# DRB CASE ACTION LOG (SITE PLAN B.P.)

DRB Application No.: 04DRB-01094 (SBP)  
Project Name: NO. ALBUQ. ACRES UNIT B  
Agent: Dorman Breen Architects

**CITY OF ALBUQUERQUE  
PLANNING DEPARTMENT  
July 21, 2004  
Development Review Board  
Comments**

**RE: Albuquerque Sign Print/SPBP**

LANDSCAPE PLAN

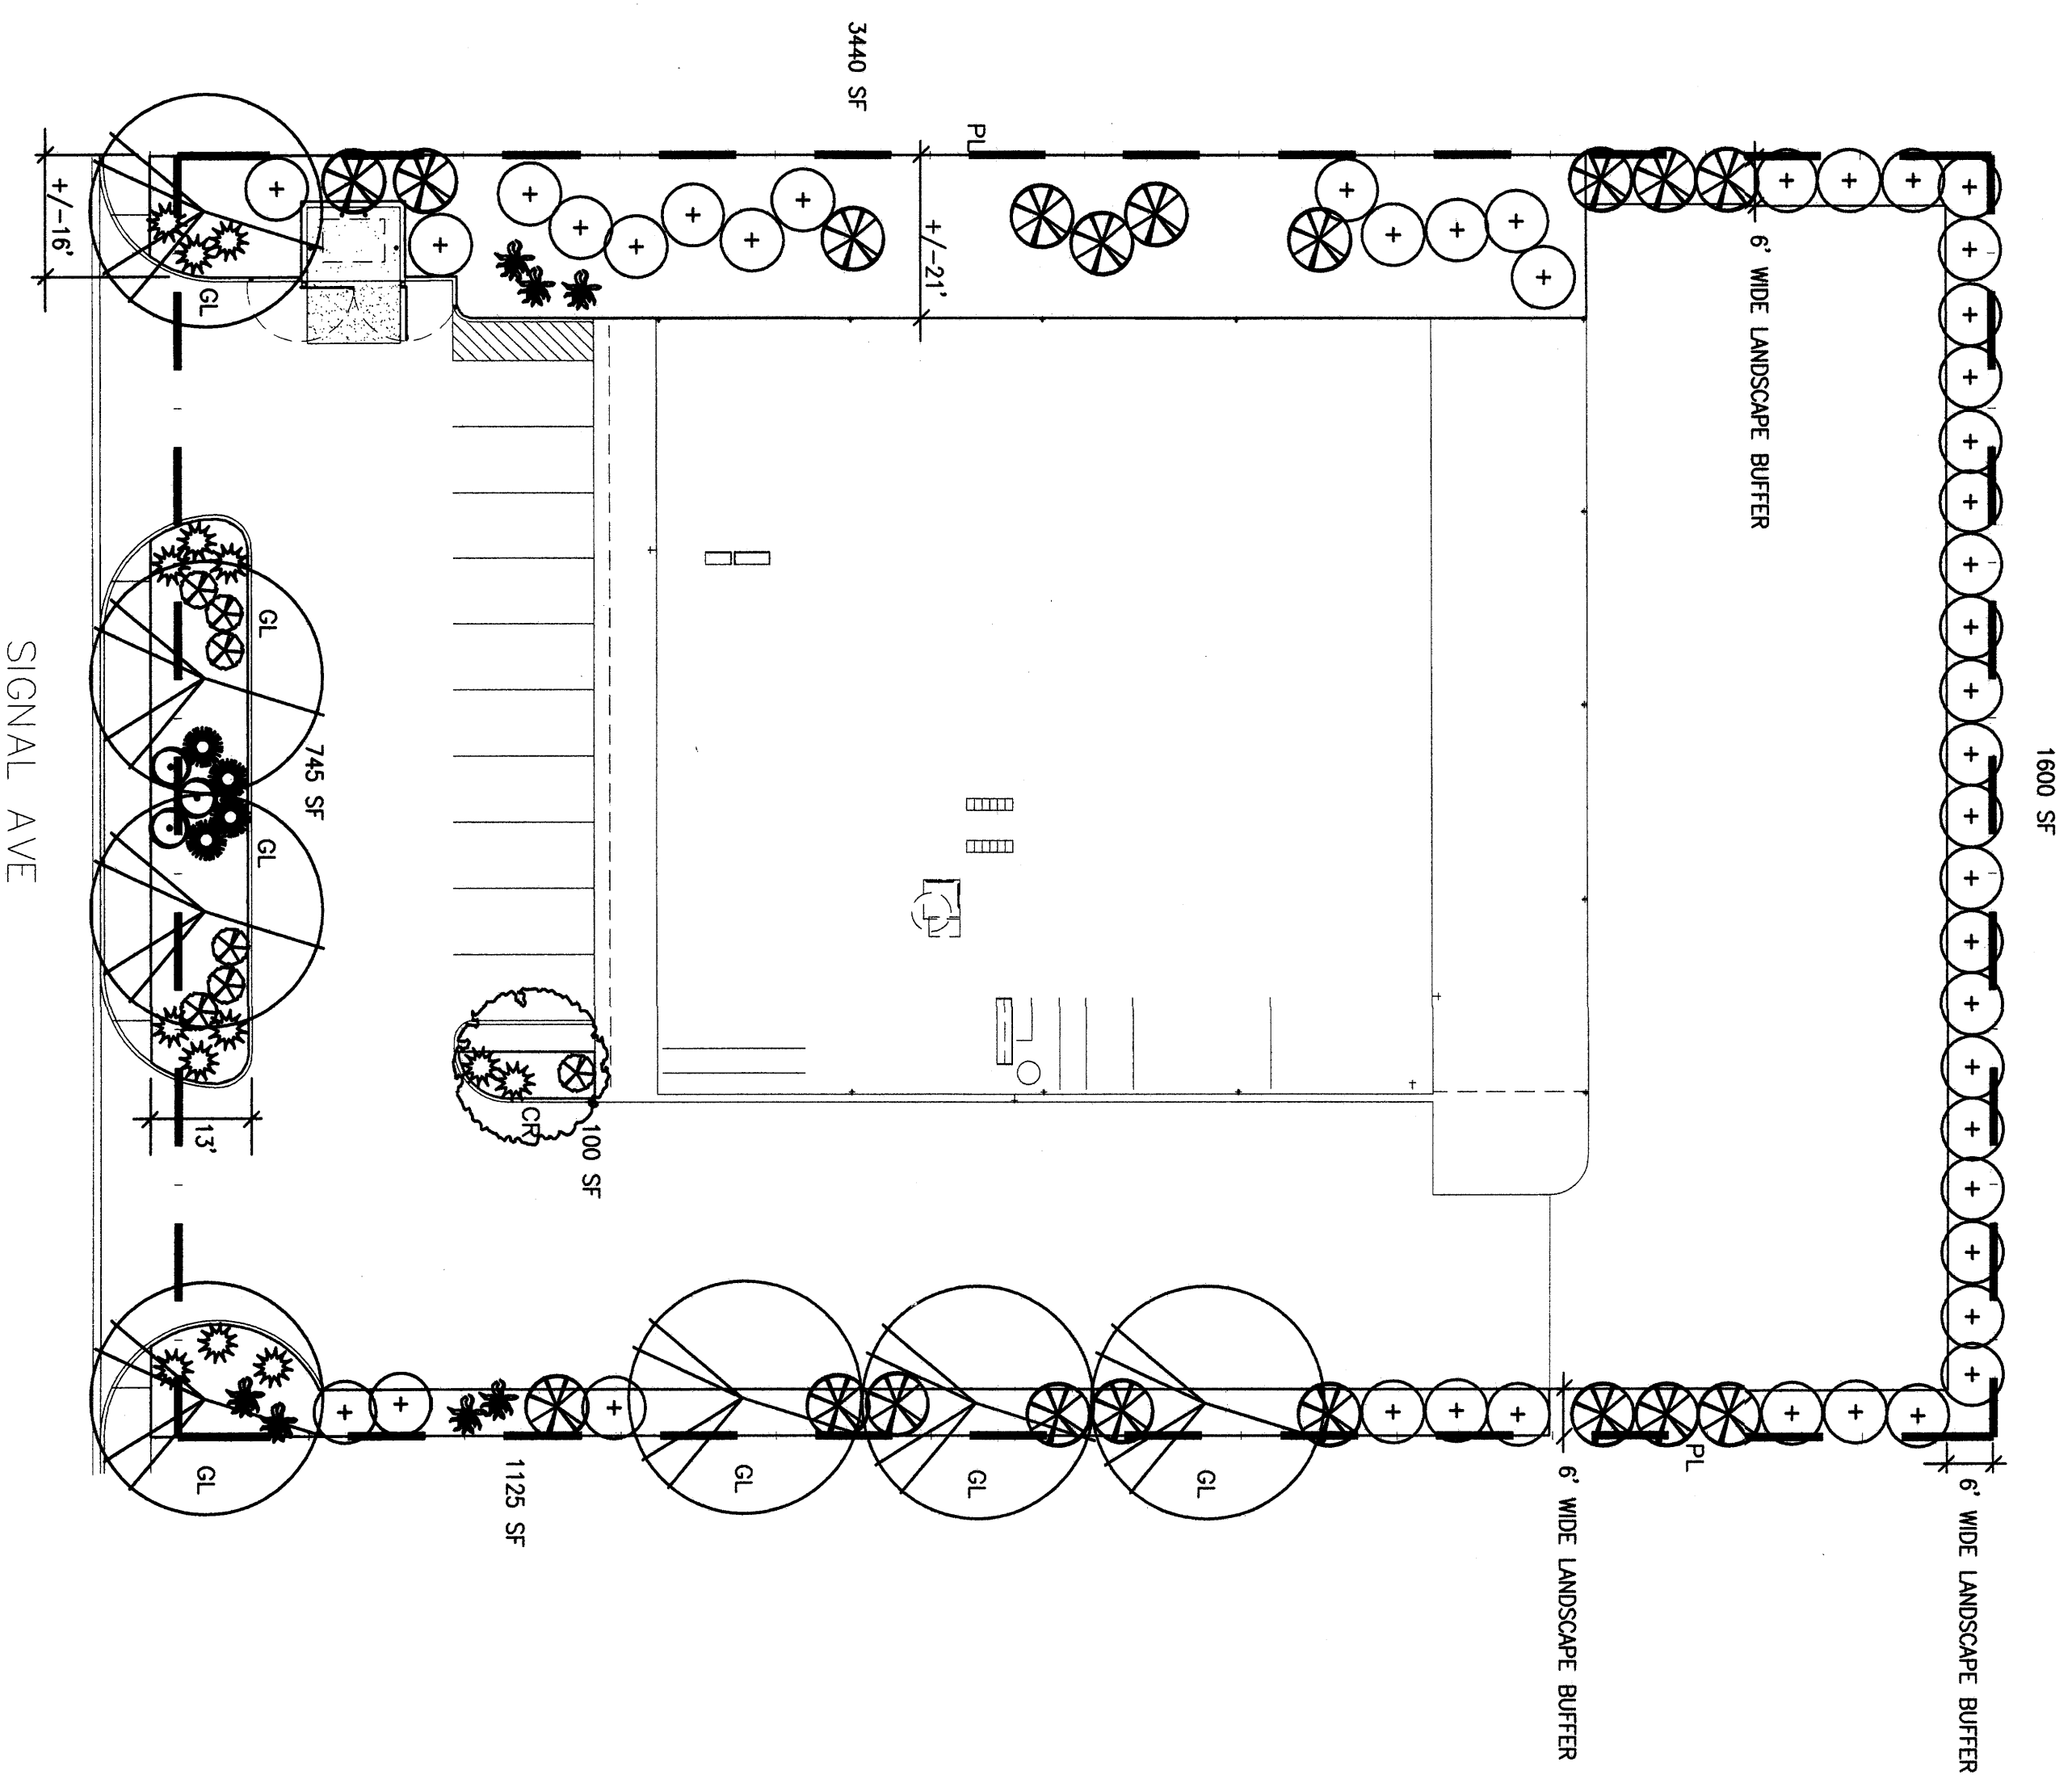
3. In addition to the total square footage for the landscaped areas, the dimensions are needed to ensure the required buffers are in compliance with the North I25 Sector Plan.

4. The Sector Plan also requires a 6' wide landscape buffer along the rear property line. The west side landscape buffer should contain trees to provide shade for the building per the North I25 Sector Plan Design Standards.

6. Please include the standard language on the landscape plan. A copy is attached to these comments.
7. The property lines are not clearly identified. Use a bold line & identify.

10. The trash enclosure elevation is missing.
11. Please remove the junipers from the Landscape Plan.
